November 16, 1981

Re: Fellowship Christian Reformed Church

REFERENCE: Drainage Inspection at 4800 Indian School Rd. N.E.

CHRISTIAN REFORMED CHURCH

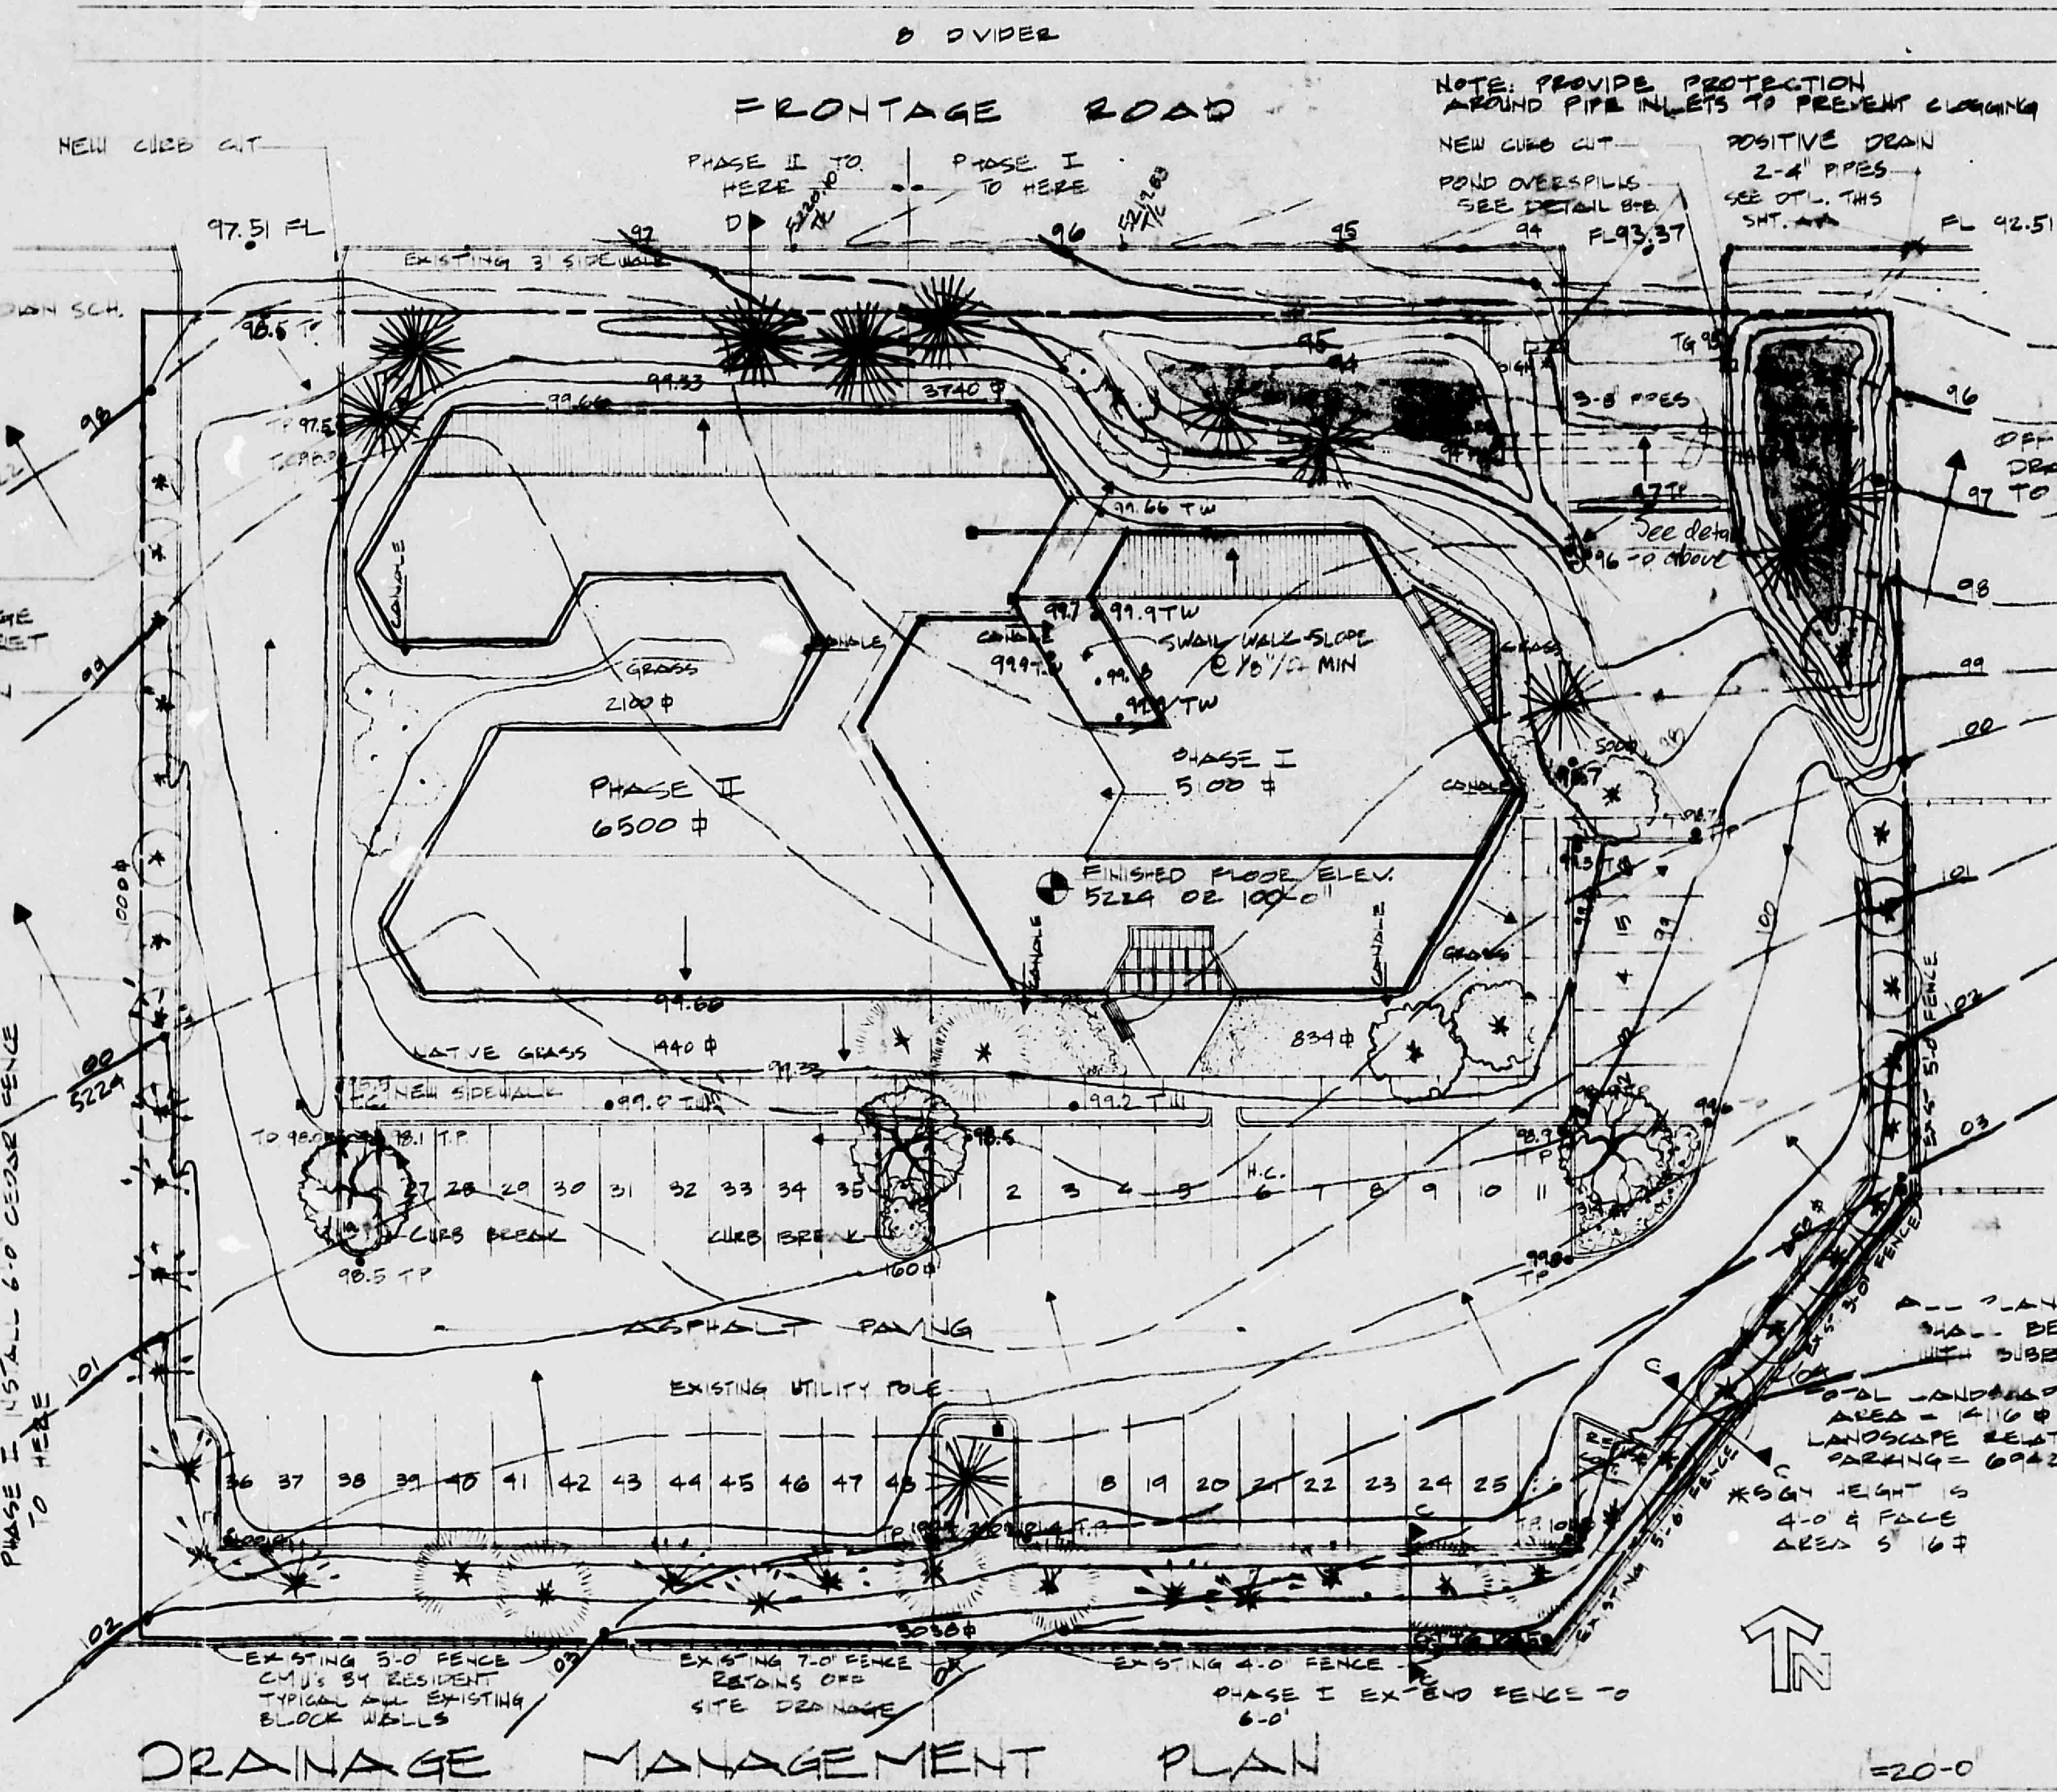
1. Both ponds 1 and 2 should have well defined points of overspill. Specifically, I recommend the following: The grassed berm around pond #1 should be depressed a minimum of 6" in depth and 2' in width at its northeast corner to define the overspill point. The grass landscaping should provide adequate erosion control, therefore, no concrete pad will be required.

The berm around pond #2 should be built up along its north side to define a point of overspill at the northwest corner to similar dimensions as described for pond #1. 3"-6" cobbles with a heavy underlying plastic sheet should be laid at the depressed overspill and out to the asphalt paving as an erosion control measure. No concrete pad will be required if this is done.

2. I agree with your recommendation that the swale around the west side of the building be reworked so that water will enter pond #1 rather than continuing north to the street as it currently does.

3. The risers on the 8" pond interconnect pipes should be removed so that the flow line elevations of the pipes will be flush with the pond bottom. It is critical that this be accomplished to allow the pond to completely drain.

4. The riser on the 4" positive drain pipe in pond #2 should be removed so that the flow line elevation of the pipe be flush with the bottom of the pond. This will allow the pond to drain.
